Application Number S6/2014/1982/FP

Description of Development Erection of single storey rear extension and new porch following demolition of existing sun room

Recommendation GRANT CONDITIONALLY

Drg. No
 732 / 01

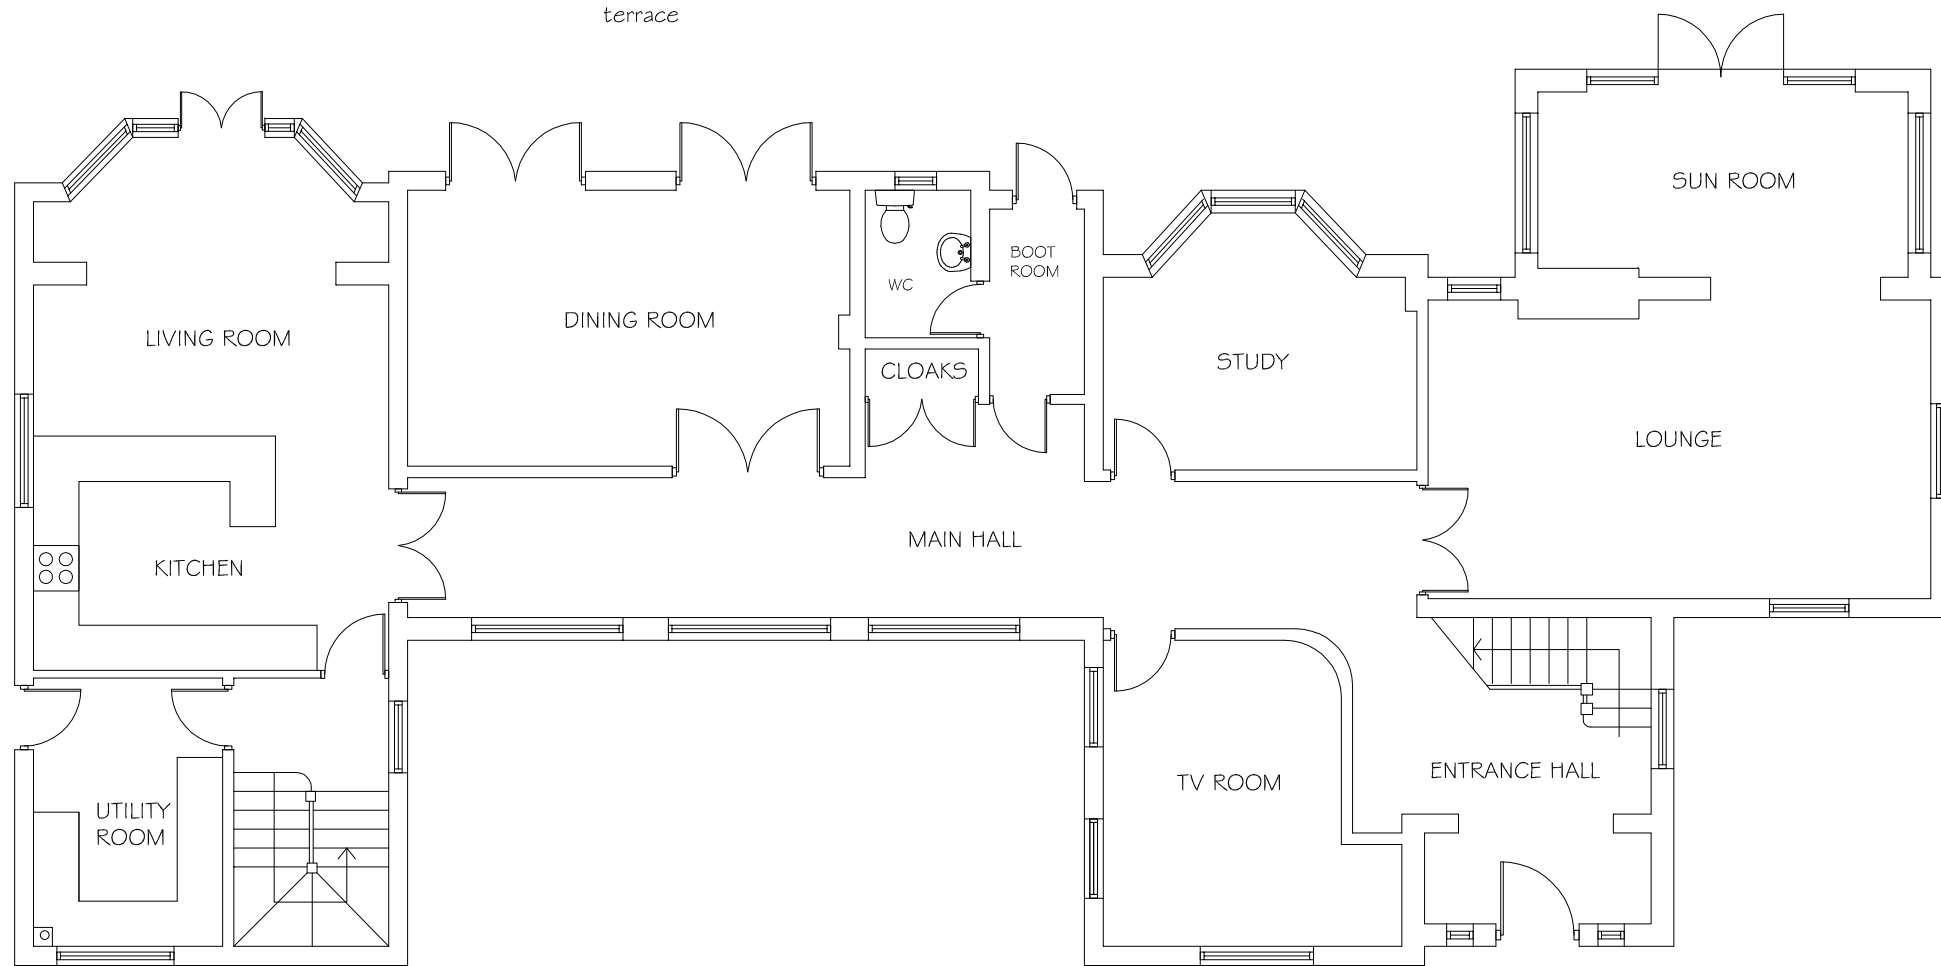
3. C.5.2 – Matching materials
4. The existing ‘Sun Room’, as labeled on submitted plan 732/01, shall be demolished and all the materials arising from such demolition shall be completely removed from the site prior to the first occupation of the approved development.

Drg. No
 732 / 03

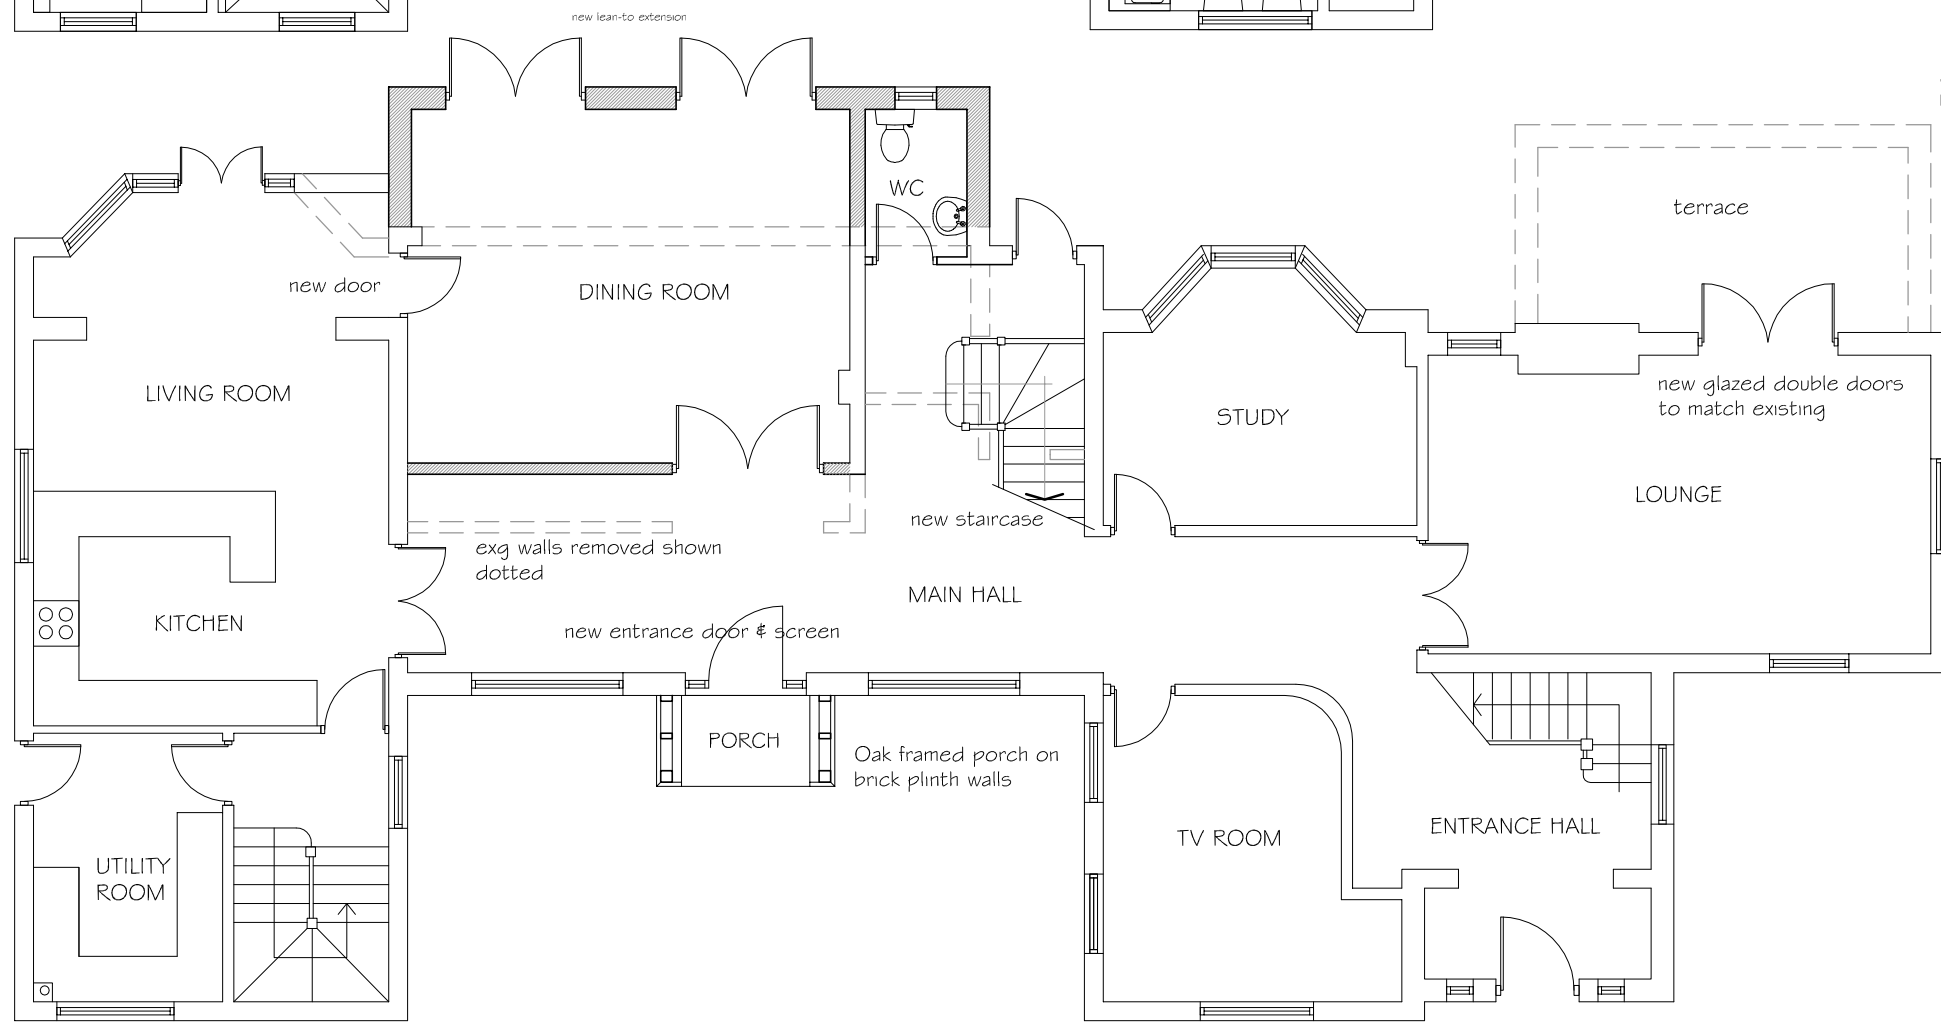
Comment: Floor area of original dwelling, as it existed in 1948, has been calculated as approximately 162sqm. Previous extensions have resulted in 128% increase in terms of floor area compared to original. Proposed rear extension would result in additional 10.2m². However, element to be demolished is approximately 11.5m² in floor area. On this basis, it is considered that, subject to a relevant condition requiring the 'Sun Room' as shown on plan 732/01 to be demolished, the proposed rear extension would not add a significant amount of bulk and mass to the property and would not represent a disproportionate addition to the already significantly extended property. Furthermore, given the build and form of the proposed porch, it is considered that this element of the works is also appropriate. With regard to the impacts on openness, purposes of including land within the Green Belt and visual amenity of the Green Belt, it is considered that the proposal, which does not significantly extend the built footprint of the property, would not result in significant harm in this regard to the extent that would warrant a refusal of permission.

Drg. No
 732 / 04

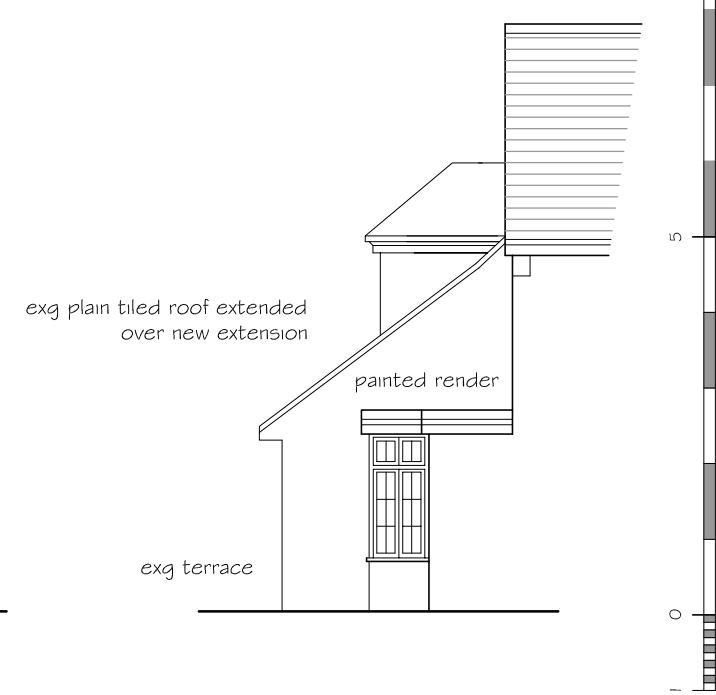
Comment: Limited views of proposed development and the works remain subordinate in form and acceptable in design.
